Office of
Environment
& Heritage

DOC17/646767-1
SSD6698

Coppabella Wind Farm – Site visit outcomes

Coppabella Wind Farm - Environmental Assessment for Modification One

Coppabella Wind Farm

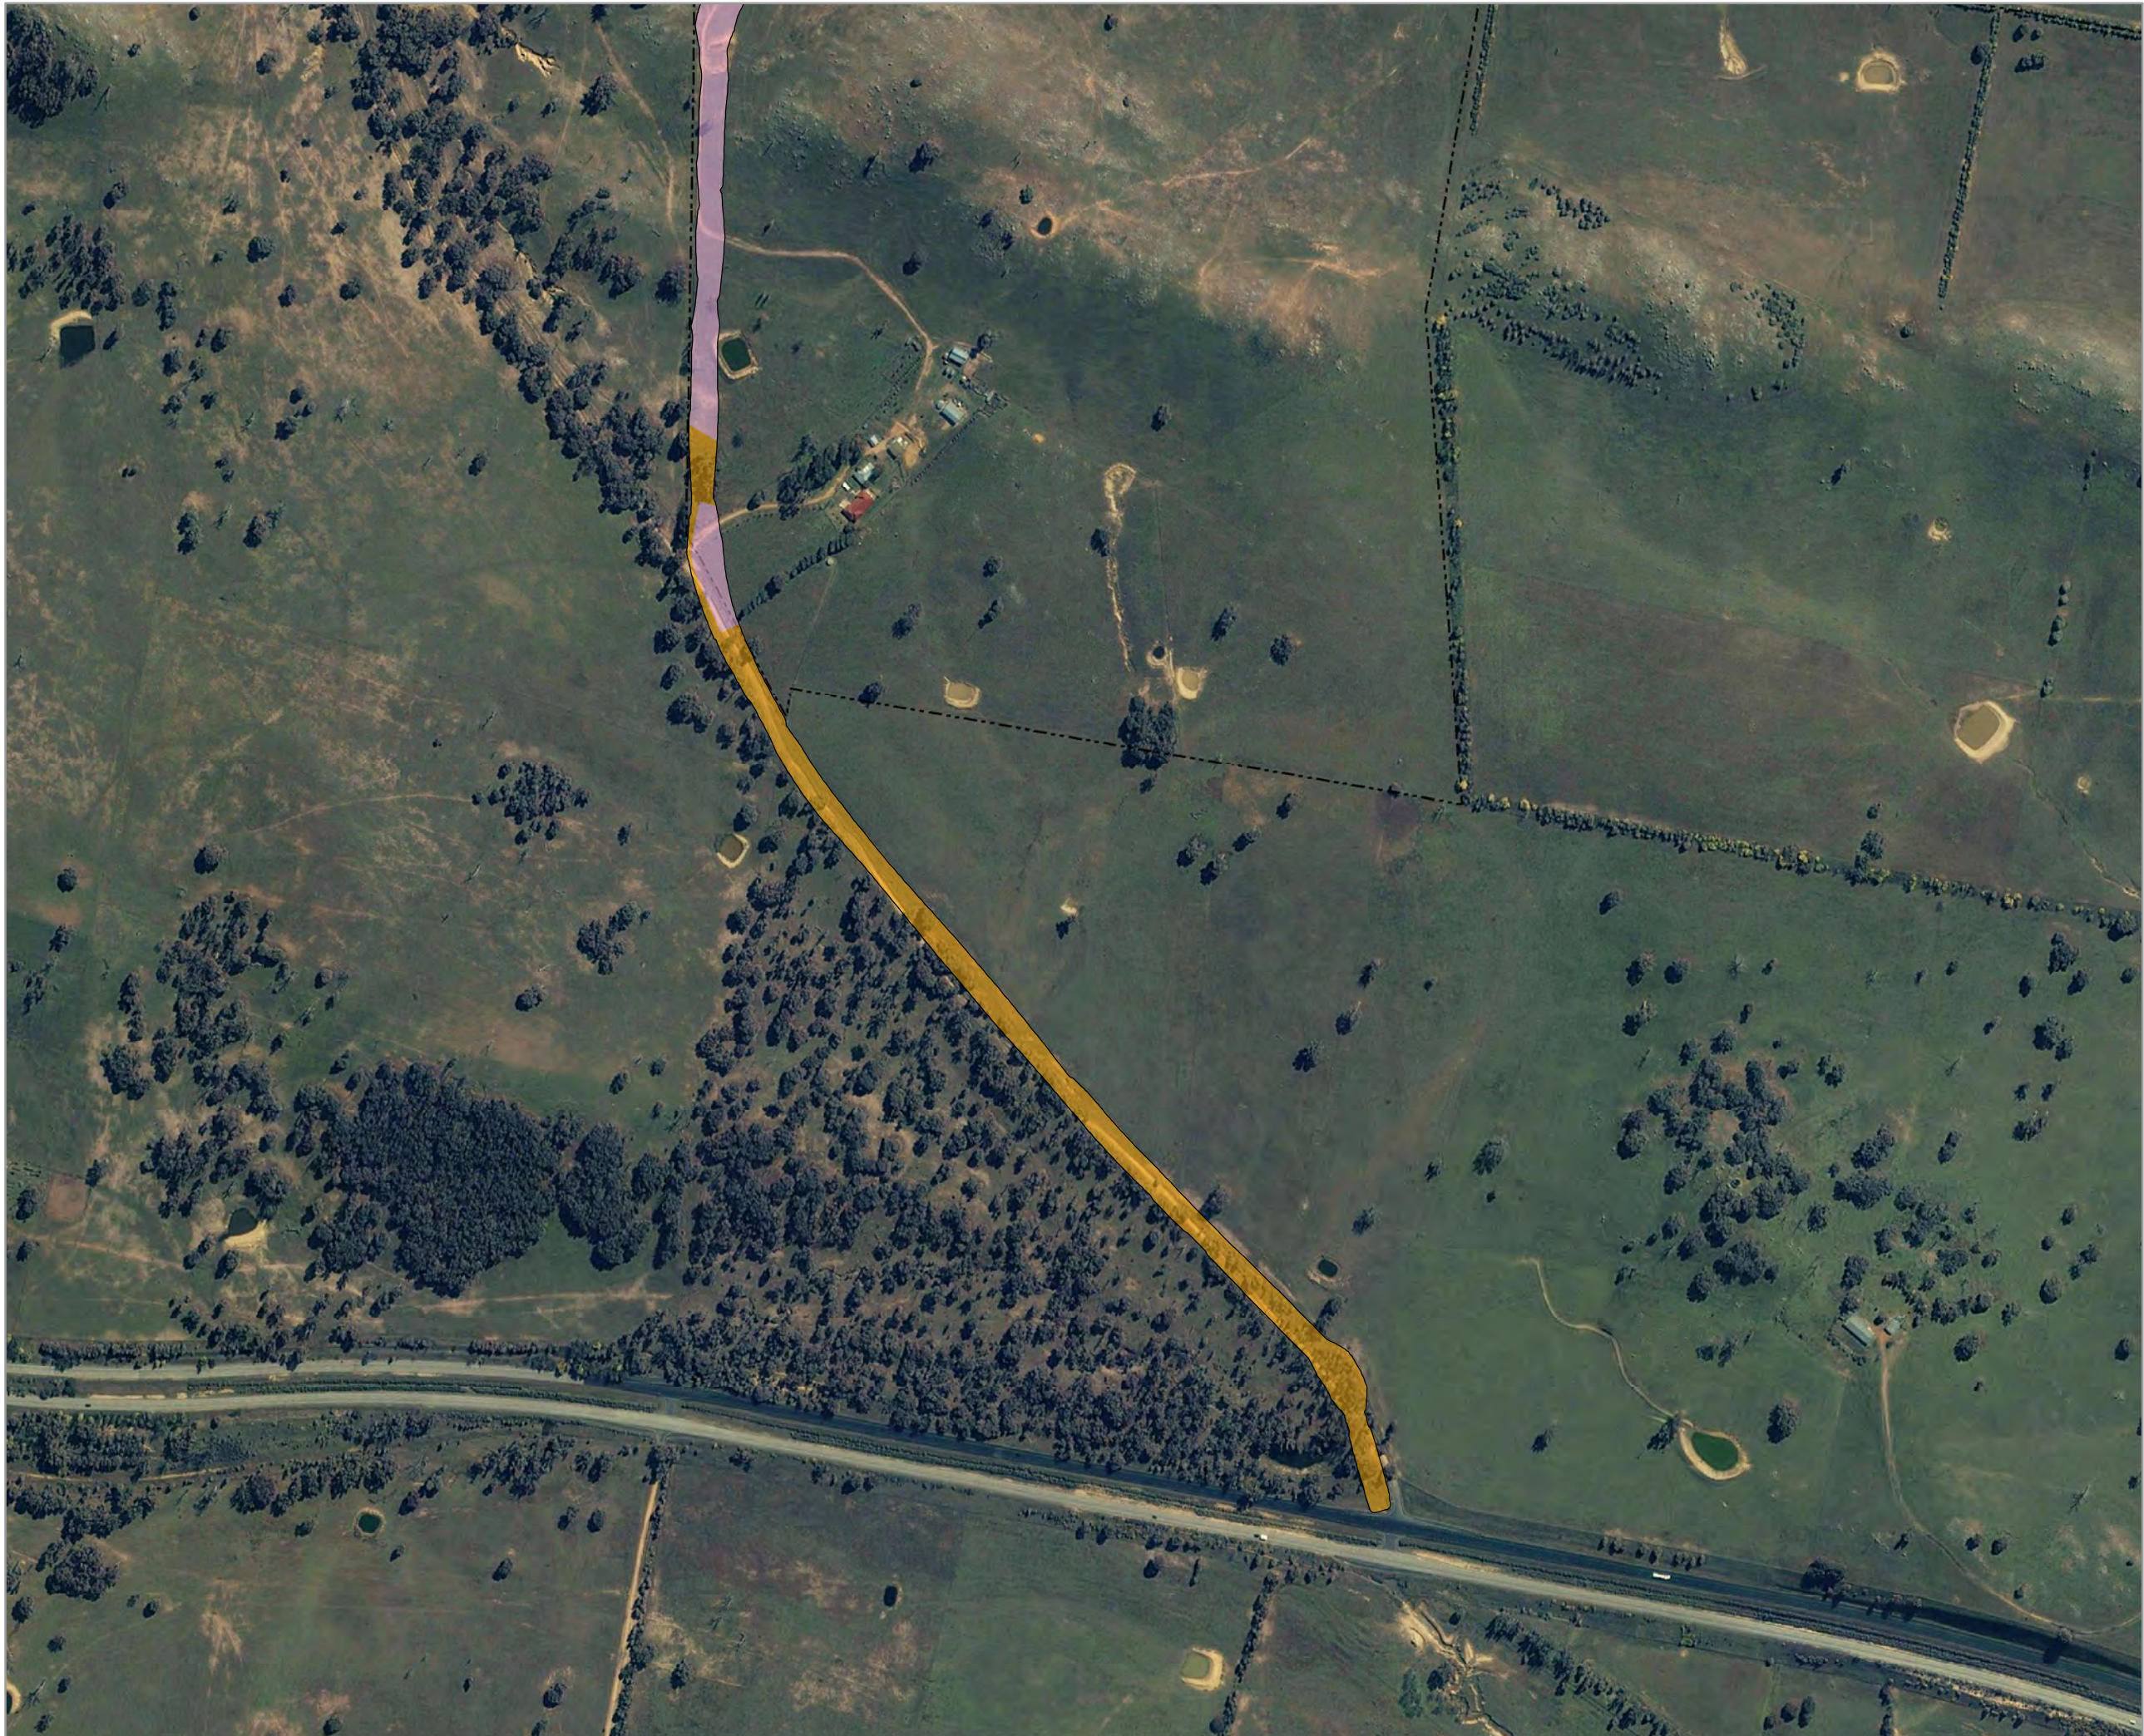
OEH's internal Reference	Easting and Northing GDA94	What the area is currently mapped as	Site inspection finding	OEH's recommended action	Map or photo reference
Photo point FID 3	643560 6151889	Exotic	Confirmed exotic.	None required	n/a
Photo point FID 4	643630 6152117	Exotic	Confirmed exotic.	None required	n/a
Photo point FID 7 – to FID 10	644242 6154023 To 644470 6153861	Exotic	This area is the Box Gum Woodland derived native grassland. NGH agreed on site.	change mapping in this area to Box Gum Woodland derived native grassland (EEC).	Area mapped on Map 1 below.
Photo point FID 13	642206 6154029	This area is mostly mapped as exotic, with small sections of Box Gum woodland - Moderate to good (low) mapped where the trees are.	The trees are close enough to mean the whole area should be mapped as the Box Gum Woodland vegetation moderate to good – the groundcover is also native (not exotic). There is a substantial Yellow Box tree with hollows in this area that should be protected during construction and operation.	Update mapping of this area to Box Gum Woodland (EEC) - moderate to good condition. Move infrastructure into the more degraded areas.	Area mapped on Map 2 below.

Photo point FID 15	641768 6154245	Exotic	Confirmed exotic.	None required	n/a
Photo point FID 16	641811 6154561	Box Gum woodland - Moderate to good (low) and mix of other.	Infrastructure placed in an area mapped Box Gum woodland - Moderate to good – when there are exotic	Suggest avoiding impact to the Box Gum woodland – EEC and situating the infrastructure in a cleared area.	Area mapped on Map 3 below.

cleared areas surrounding it.		
Observation point FID 2	641712 6154573	Exotic	Over 50% native. This area is the Box Gum Woodland derived native grassland. NGH agreed on site.	Update mapping in this area to Box Gum Woodland derived native grassland (EEC) - Moderate to good condition	Area mapped on Map 4 below.
Observation point FID 3	641685 6154576	Box Gum Woodland derived native grassland - low (exotic)	Over 50% native. Box Gum Woodland derived native grassland - Moderate to good	Update mapping in this area to Box Gum Woodland derived native grassland (EEC) - Moderate to good condition	Area mapped on Map 4 below.
Observation point FID 4	641390 6154488	Box Gum Woodland derived native grassland - low (exotic)	Over 50% native. Box Gum Woodland derived native grassland - Moderate to good	Update mapping in this area to Box Gum Woodland derived native grassland (EEC) - Moderate to good.	Area mapped on Map 5 below.

Observation point FID 5	641271 6154734	Box Gum Woodland derived native grassland - low (exotic)	Over 50% native. Box Gum Woodland derived native grassland - Moderate to good	Update mapping in this area to Box Gum Woodland derived native grassland (EEC) - Moderate to good	Area mapped on Map 6 below.
Observation point FID 6	642170 6155321	Exotic	Confirmed exotic.	None required	n/a
Observation point FID 7	640898 6155370	Box Gum woodland - Moderate to good (low)	Likely to meet a higher quality class – very good quality vegetation in this area with a very high number of tree hollows. Sighting of two Wedged-tail Eagles foraging in this area.	Avoid this area of important woodland – moving infrastructure to areas of degraded vegetation surrounding this patch.	Area mapped on Map 7 below.
Photo FID 18	636829 6155380	Exotic	Confirmed exotic.	None required	n/a
Photo FID 19 & 20	638515 6154116	Exotic	Borderline exotic and native. Difficult to tell due to grazing pressure.	None required	n/a
